**Consultation Response from Chris Bembridge KC,
Highways Development Management**
2023/90444 Land adj, Fern Bank, Far End Lane, Honley, Holmfirth, HD9 6NS
Erection of detached dwelling
Date Responded: 20/12/23
Responding Officer: CNB
Responding Ref: K3-49/34

These HDM comments are based on revised plans and additional information submitted by the applicant in the form of revised layout drawings No 3479 (0-) 05 Rev D dated 28/11/23 from One17 Design. These HDM comments should be read in conjunction with the two previous sets of consultation comments (submitted on 25/05/2023 and 13/10/2023 and appended below).

Appendix 3 – Swept Path Analysis of a Private Car right in left out

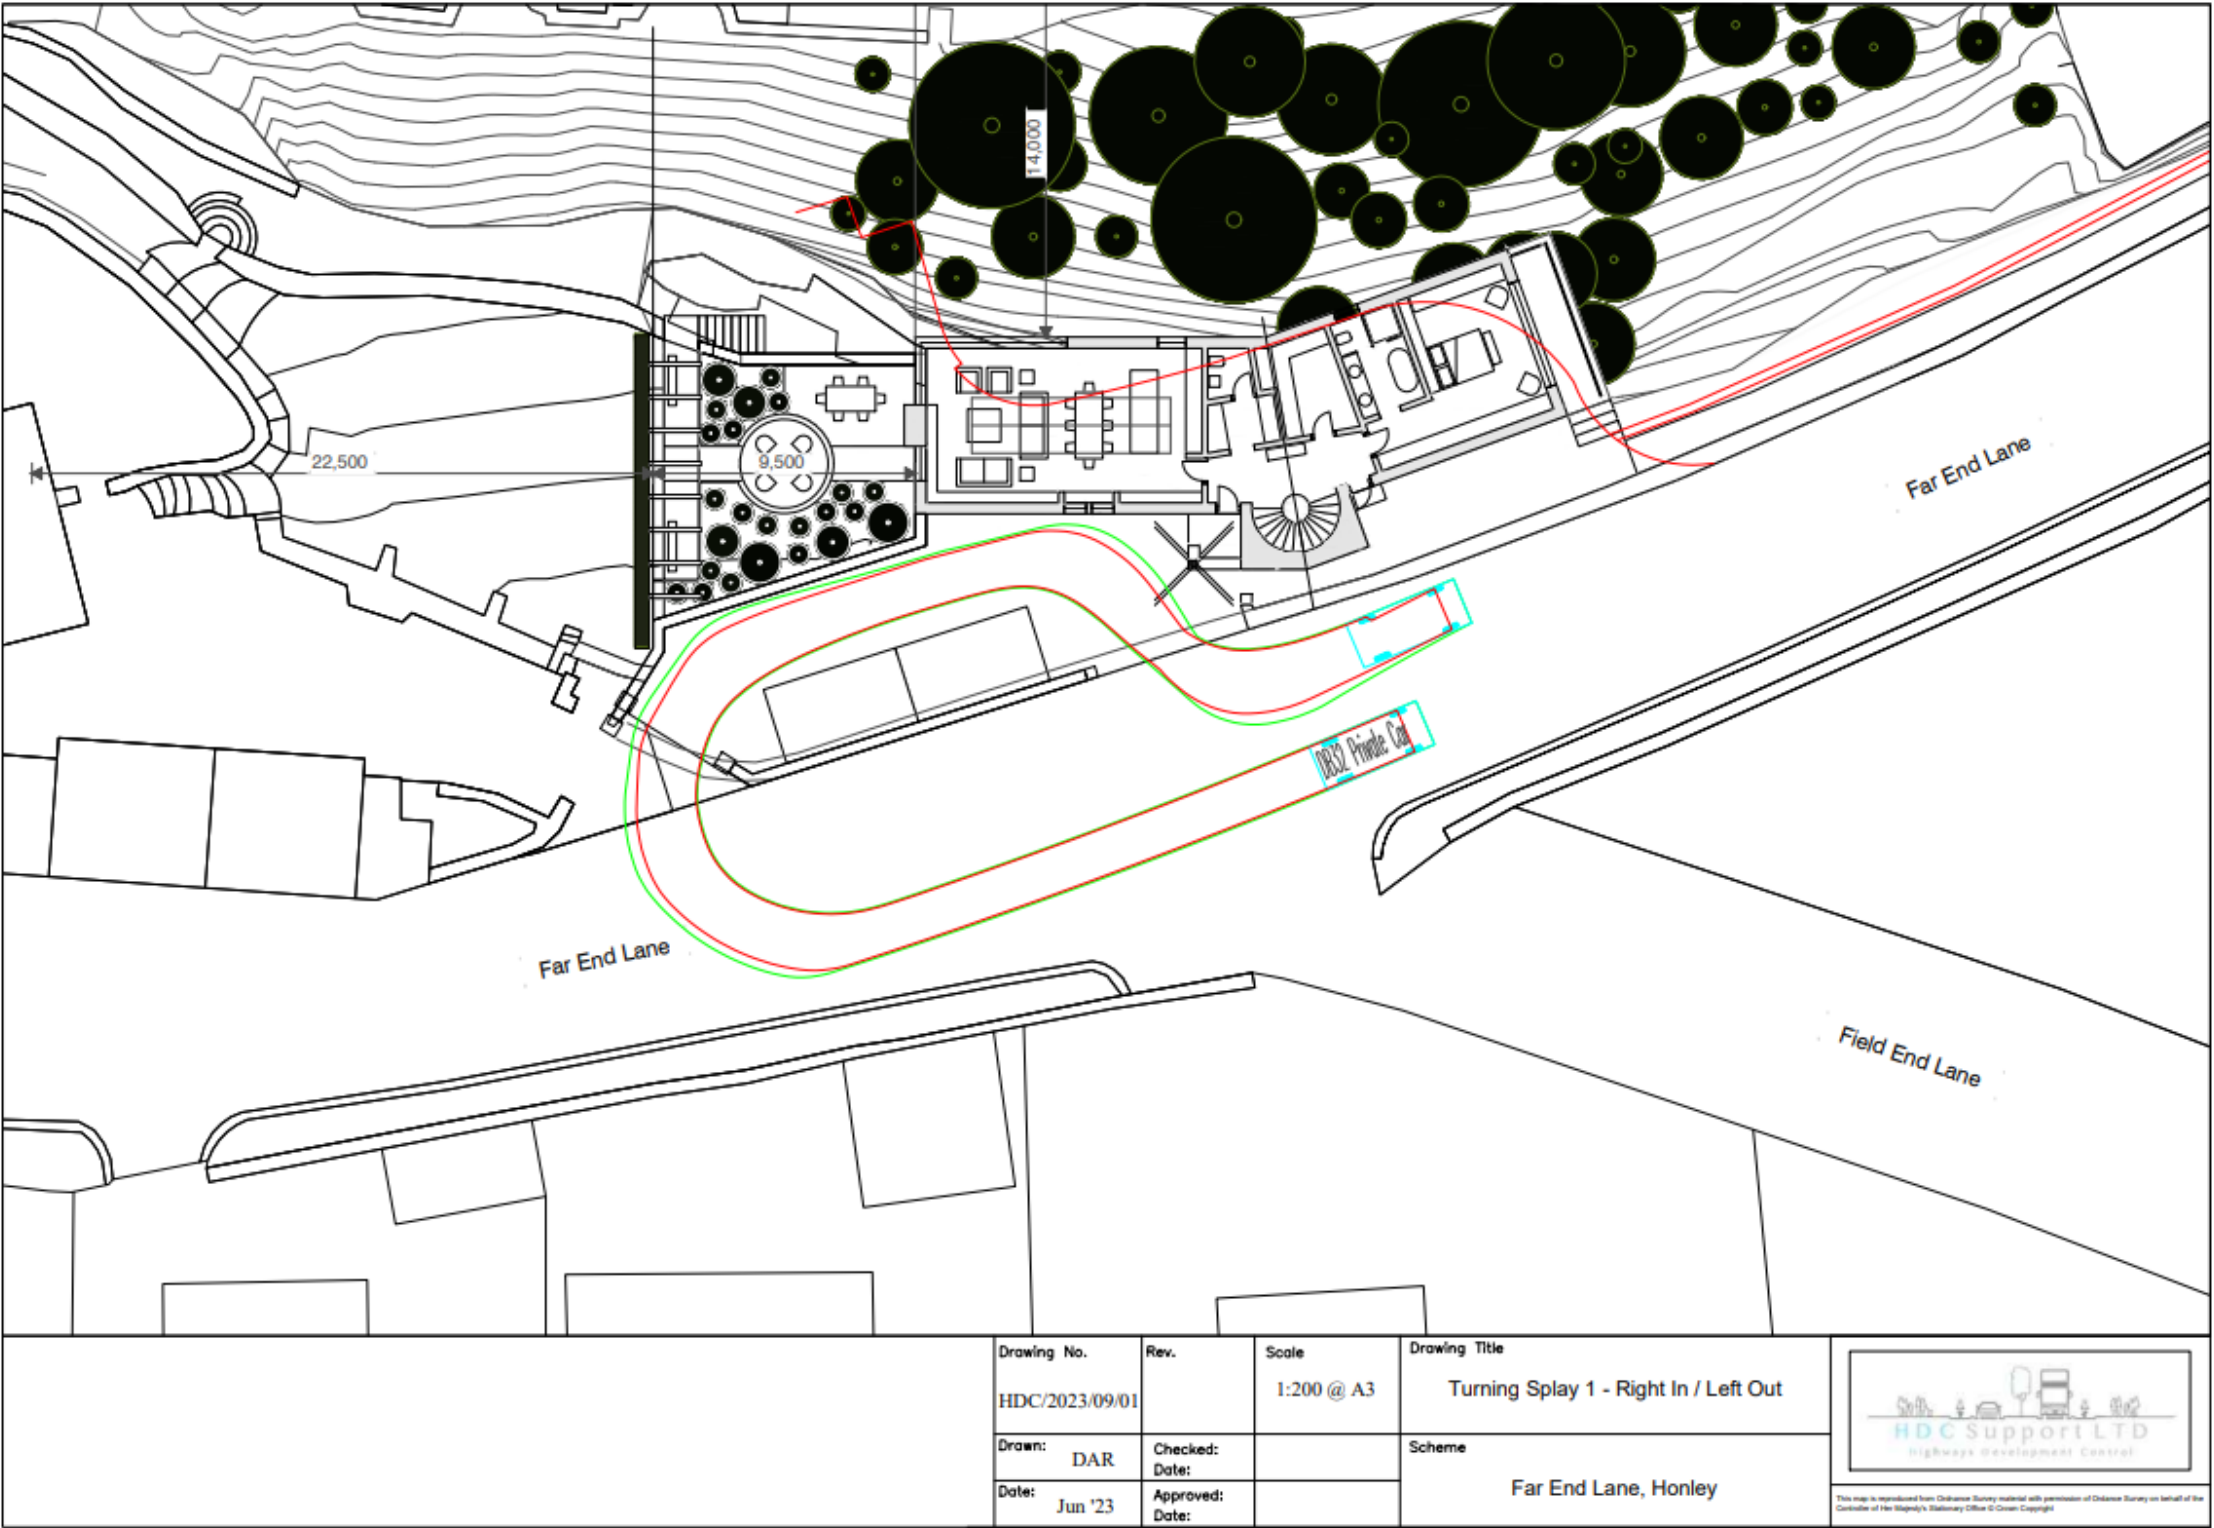
A swept path analysis was previously requested to indicate that vehicles can safely access/egress the site and this has been provided on drawings No HDC/2023/09/01 and HDC/2023/09/01, however it should be noted that the swept path drawings use the previous house design rather than the revised design. It is also noted that the swept path analysis drawings don't show the vehicles accessing the marked car parking spaces with the explanation that "Access to the parking spaces would require some element of shunting backwards and forwards" this may not make the parking spaces as desirable as they should be which may lead to a preference for people to park on the highway for ease.

Proposed Ground Floor Plan - 1:100

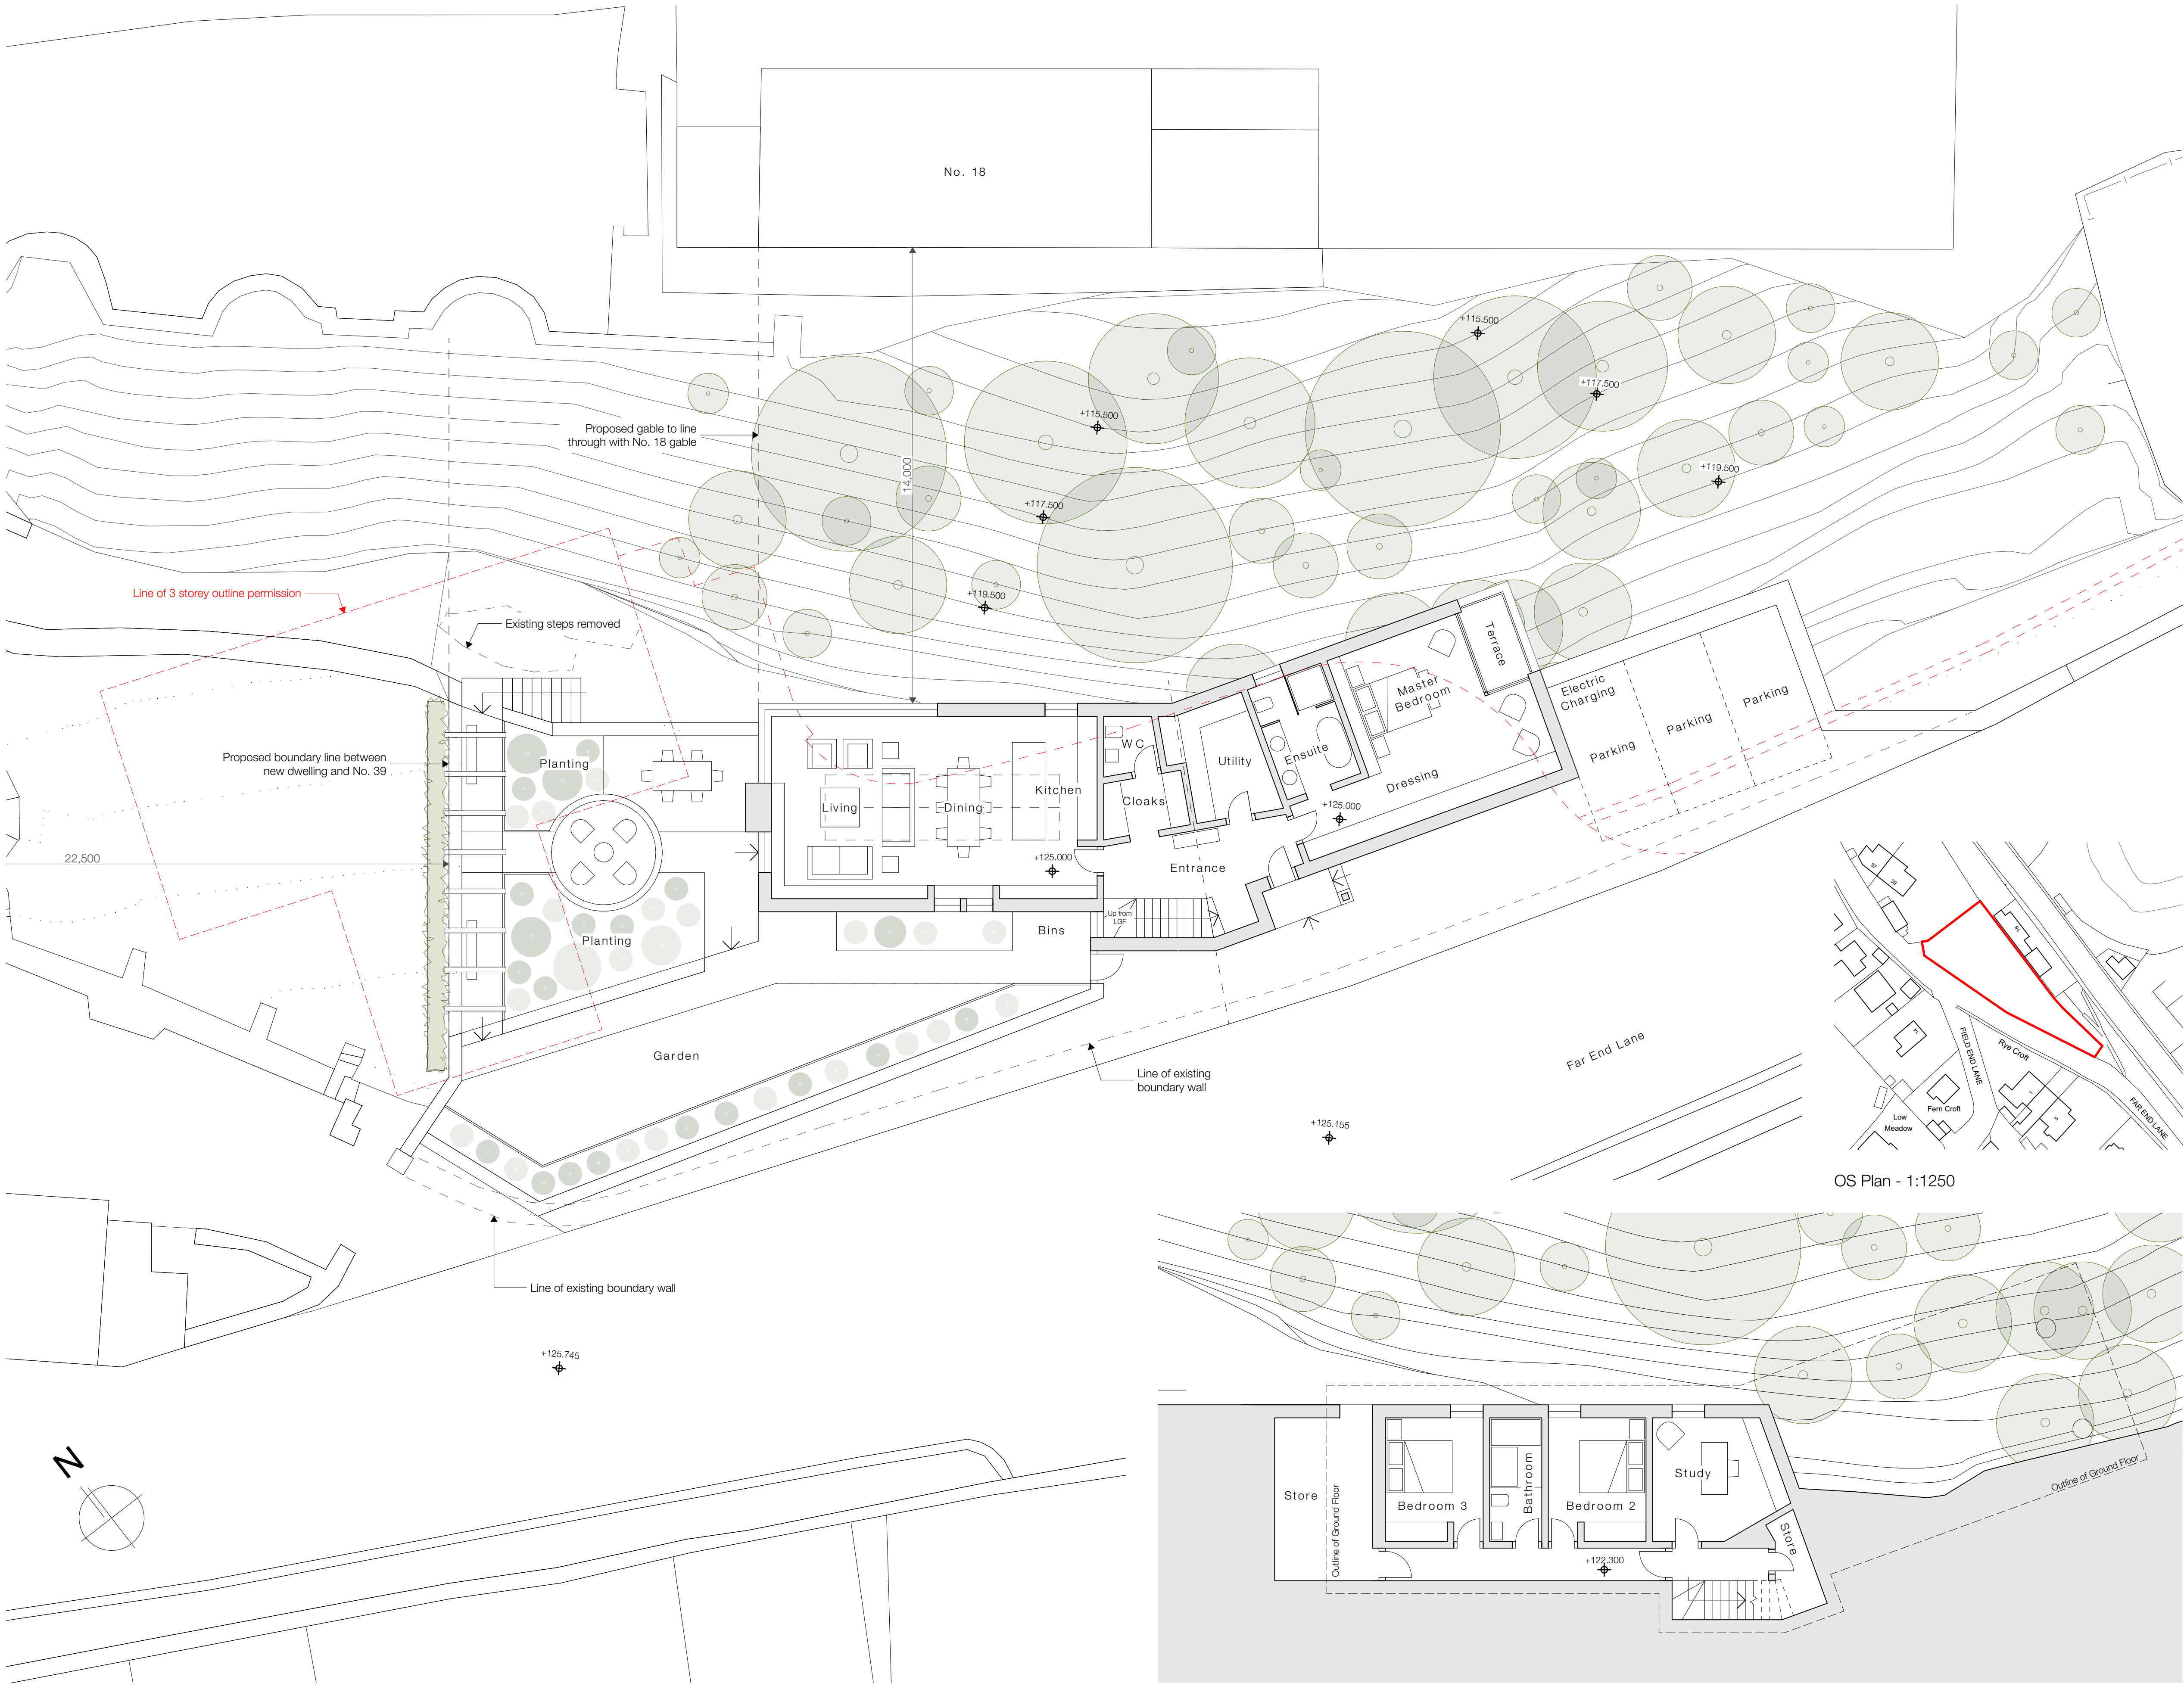
The proposals are for a 3 bed dwelling, as shown on drawing No 3479 (0-) 05 Rev D, however it is noted that there is an additional room marked as a study adjacent to the other bedrooms on the first floor and is it possible that this may be used as a fourth bedroom by future occupiers and so we have assessed the parking requirements as a 4-bed dwelling. The revised submitted drawings No 3479 (0-) 13 Rev B and No 3479 (0-) 05 Rev D all show three parking spaces of approximately 2.5m x 5m and this would be acceptable for the proposals. The spaces are set up as 90-degree parking and would require a reversing manoeuvre to access the spaces. It is noted that there are other dwellings on Far End Lane that have off street parking without turning space and so the process of reversing to park has been established in the area.

No bin collection presentation location was provided on the revised drawings, although with the removal of the wall to the front of the site, sufficient space is available for collection presentation at the rear of the adopted highway and so we would be happy to see provision of this information, indicated clearly on a drawing, as a pre-occupation condition.

Drawing No 3479 (0-) 05 Rev C shows a bin storage point, however this is located behind a gate and would not be suitable as a collection presentation point. This should be clearly marked on a drawing and should be in such a location that it is accessible to the bin collection crew but not where it would obstruct the access, parking or adopted highway for road safety reasons. This can be conditioned, and suitable wording can be provided.

Prior to the development being brought in to use, details of suitable storage, bin presentation points and access for collection of wastes from the dwelling hereby approved shall be submitted to and approved in writing by the Local Planning Authority. The approved details shall be provided before first occupation and shall be so retained thereafter.
